CITY OF ALBUQUERQUE

October 30, 2024

**RE: Event Center
1611 Airtech Ct. SE
Grading Plan
Engineer's Stamp Date: 6/11/2024
Hydrology File: L11D071**

**C-1**

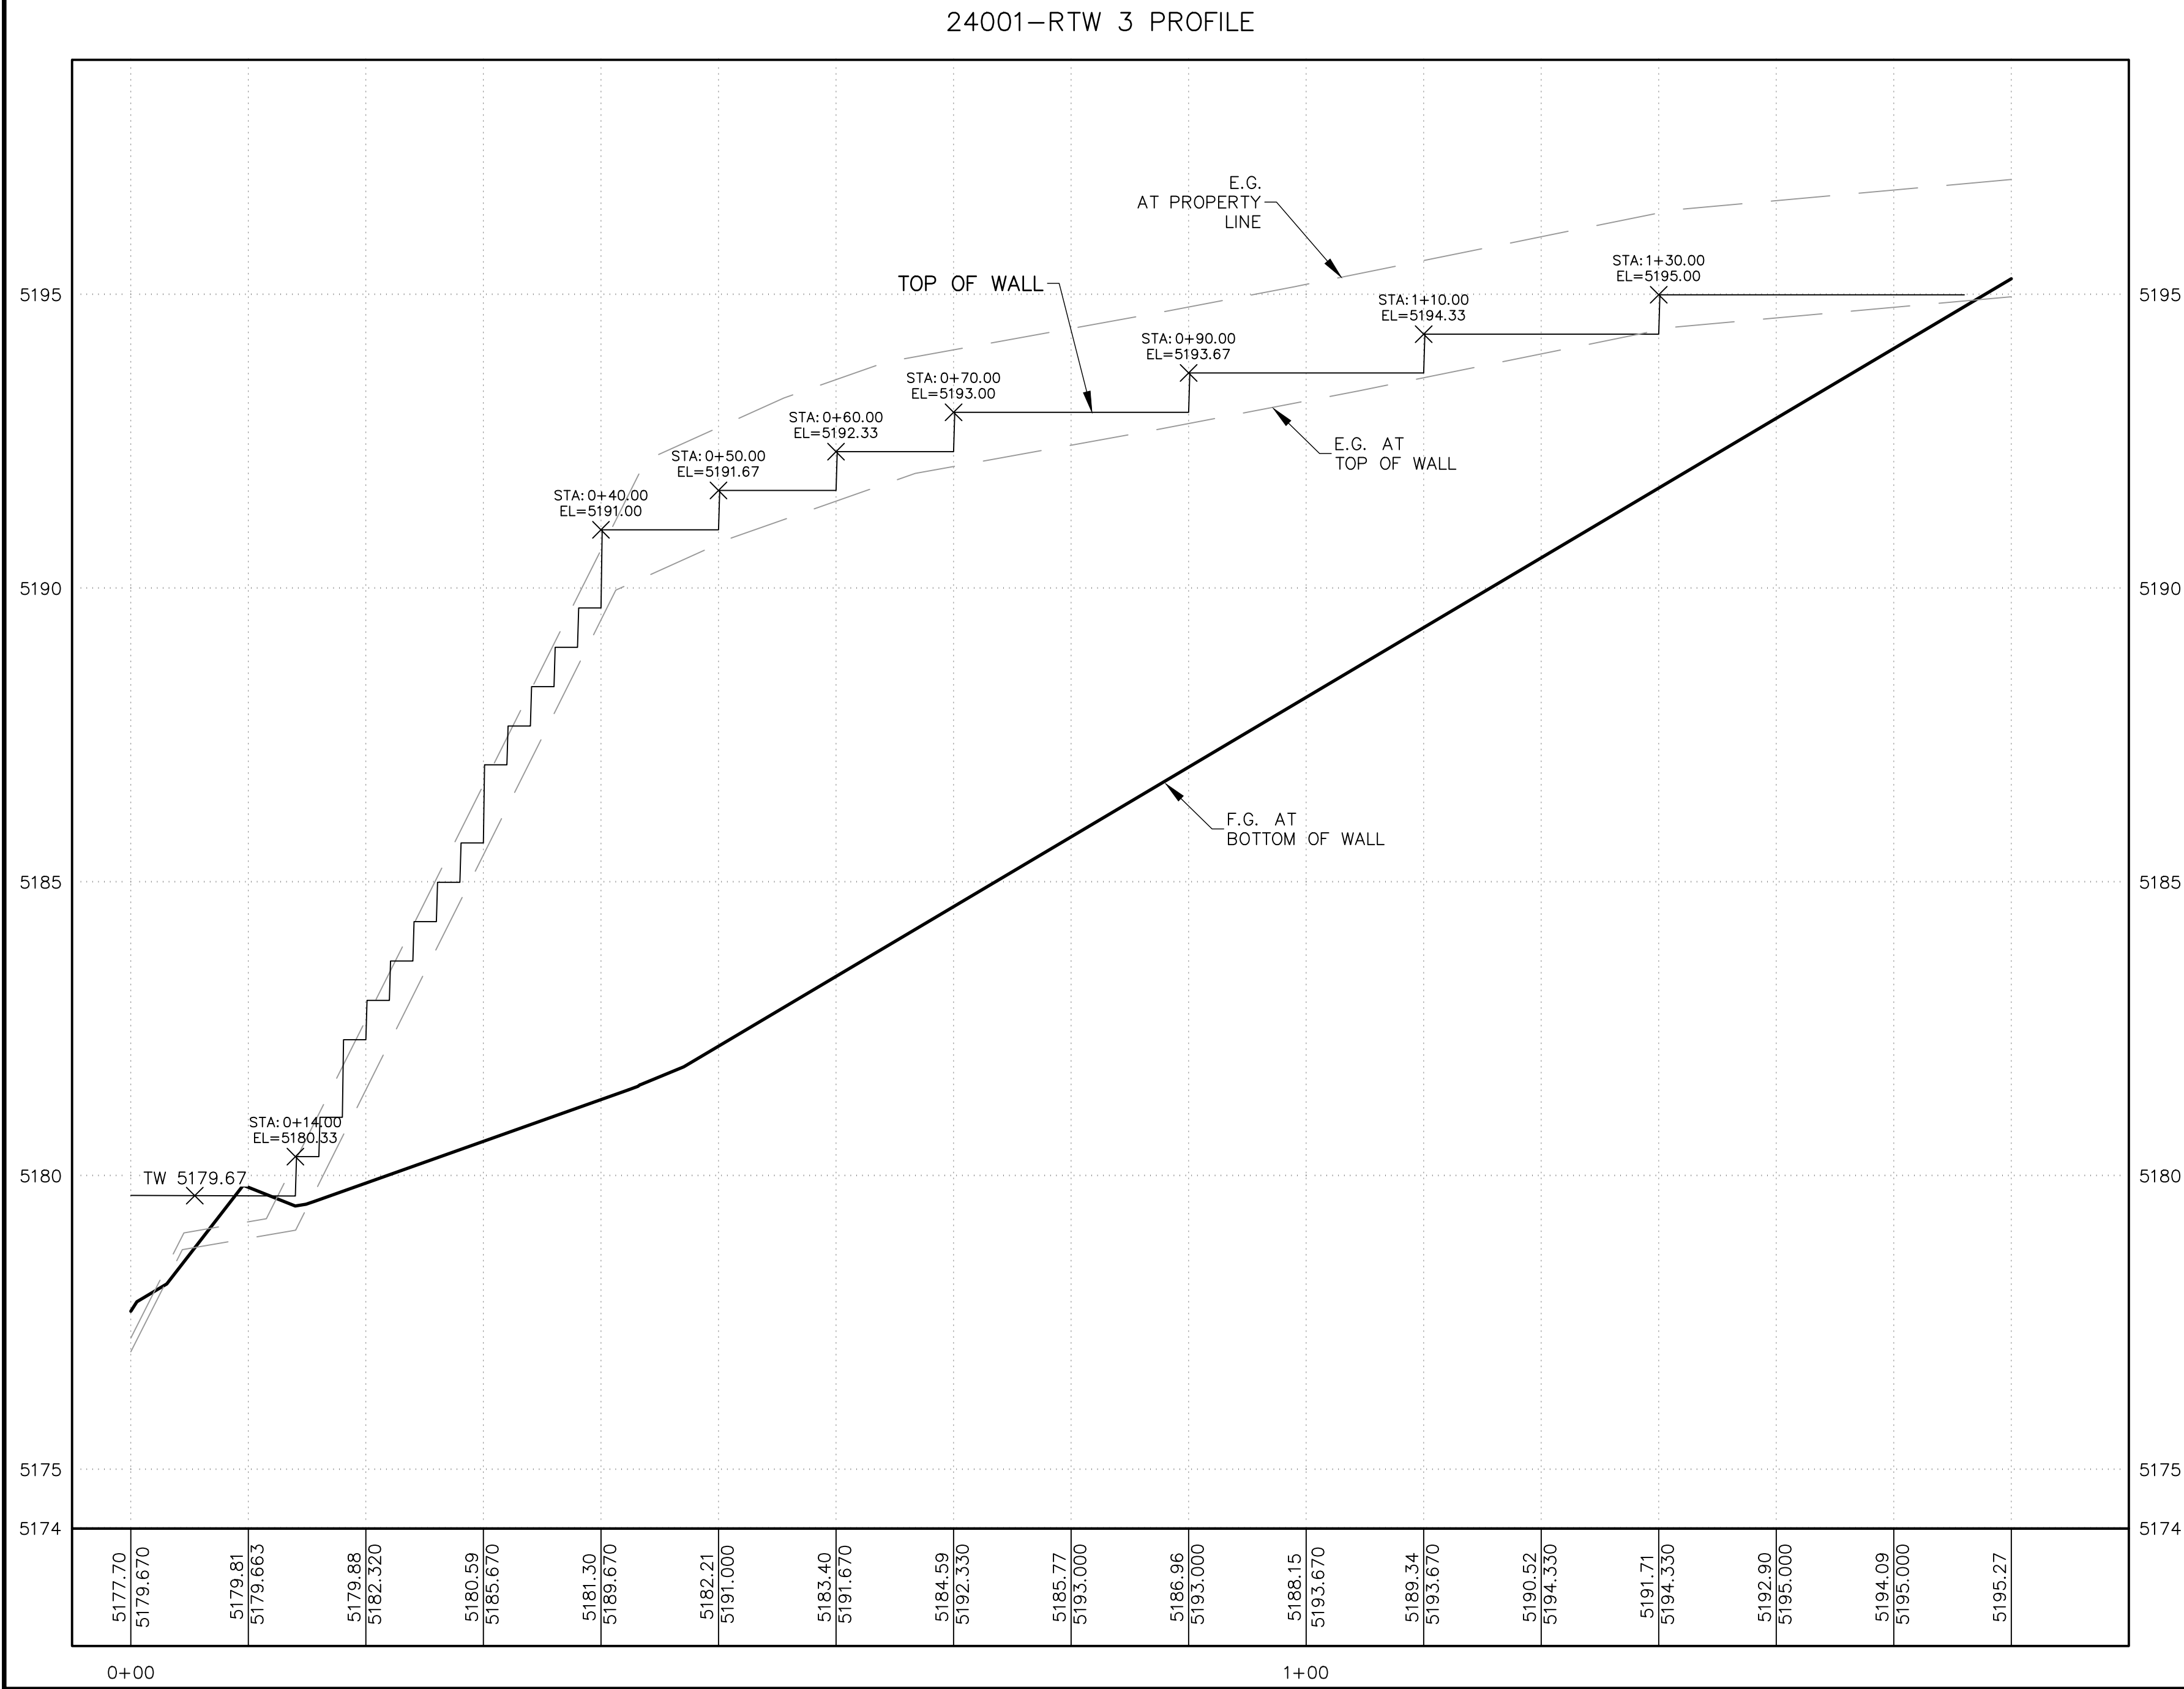
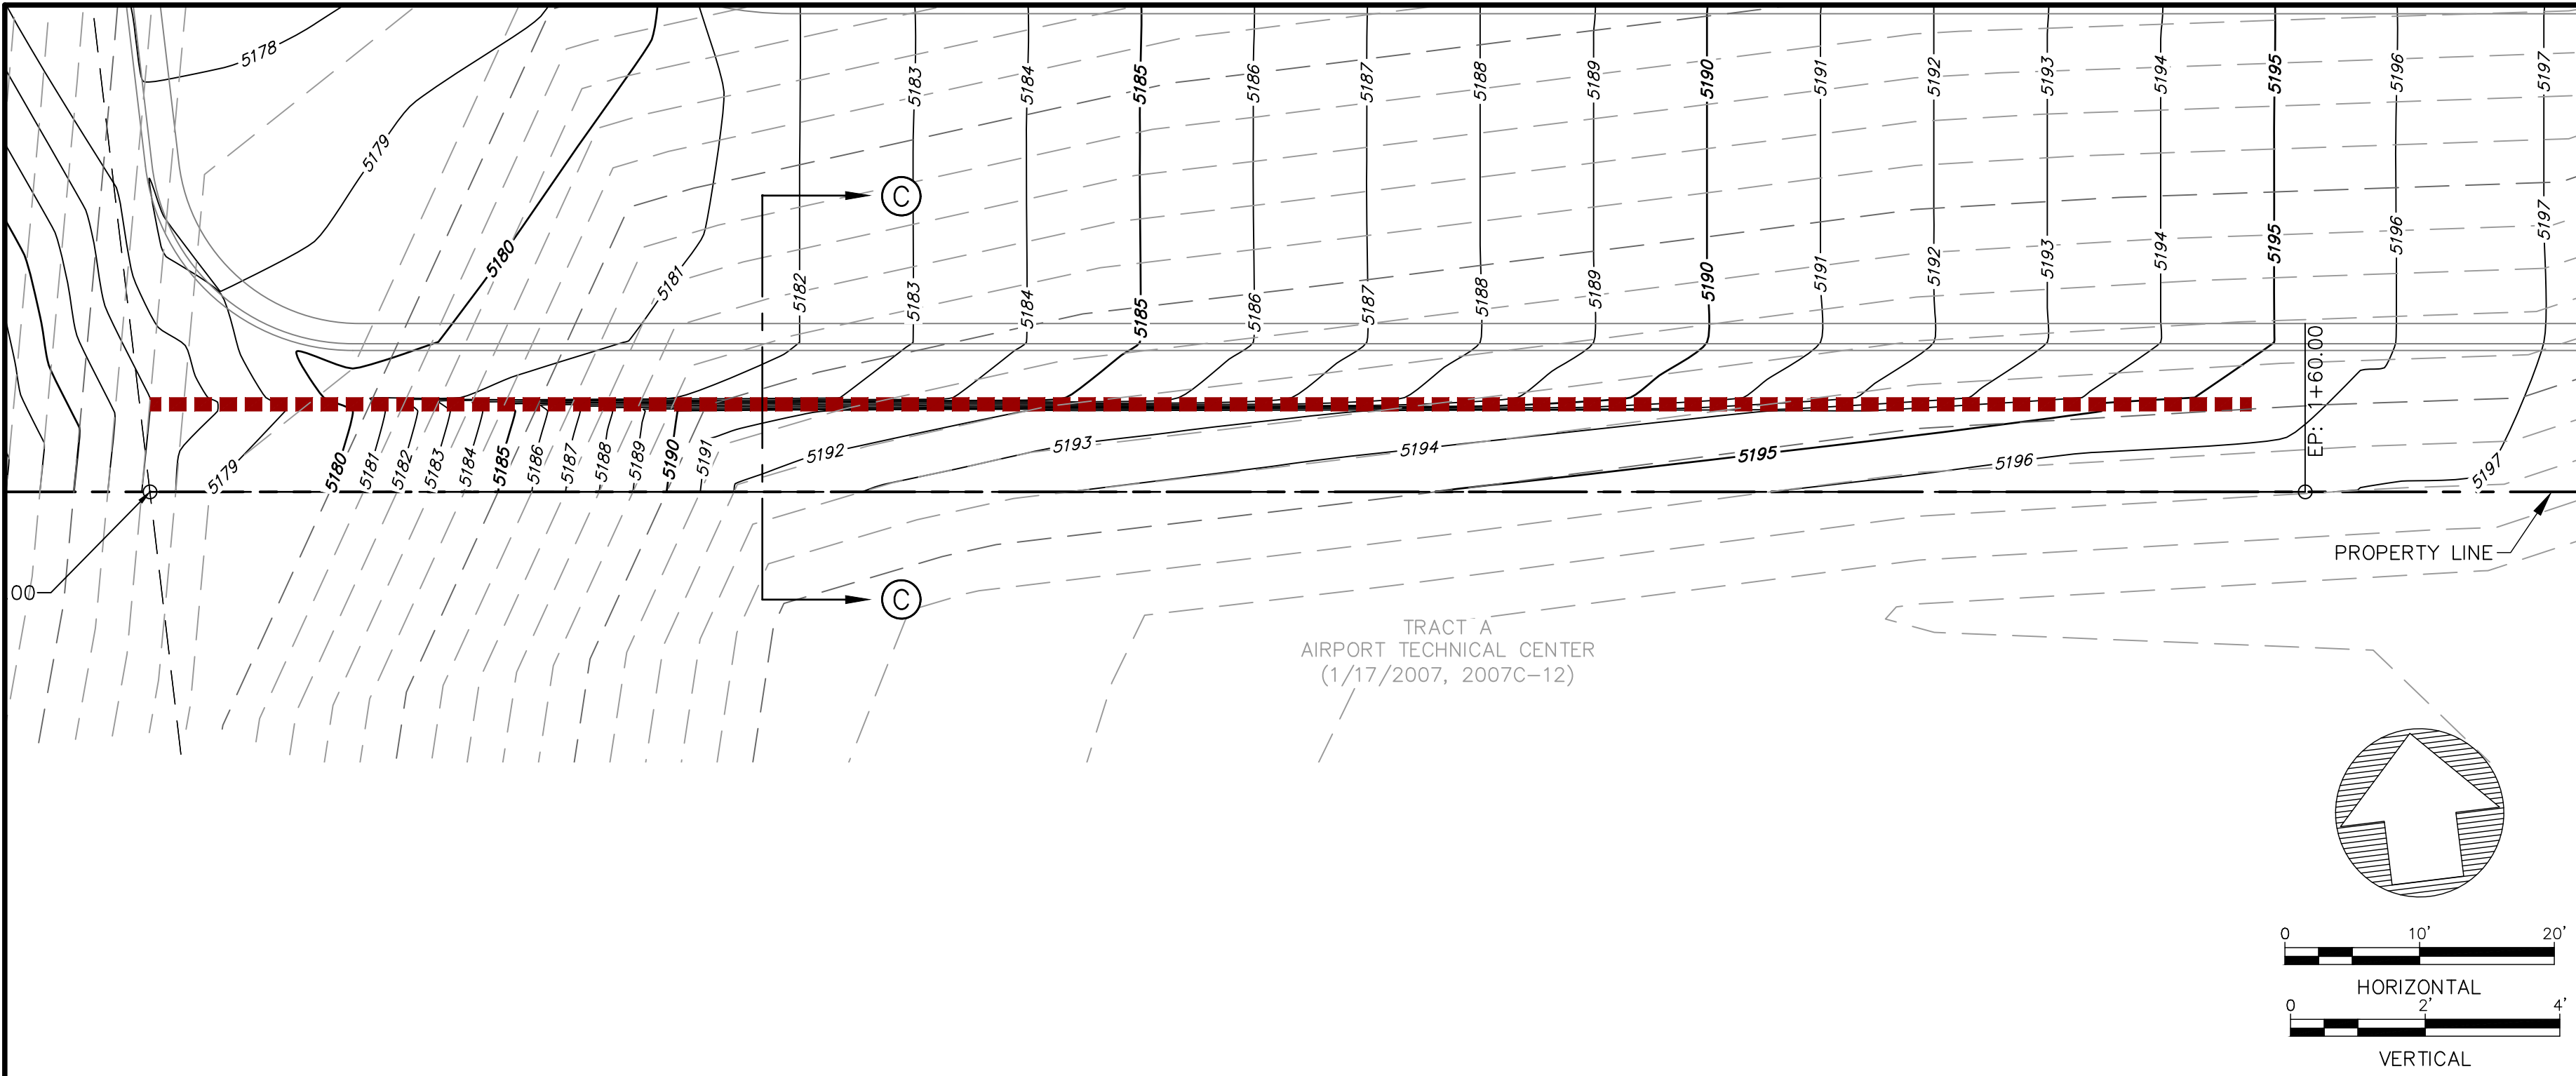
1. Payment in Lieu (Amount = 4007CF x \$8/CF = \$32,056) of onsite management of the SWQV must be made. Take three copies of the treasury deposit slip to the Treasury and then include one copy of the paid deposit slip when resubmitting.
2. Please add a note which states, "The Owner has elected to pay the Payment in Lieu for the required Stormwater Quality Volume."
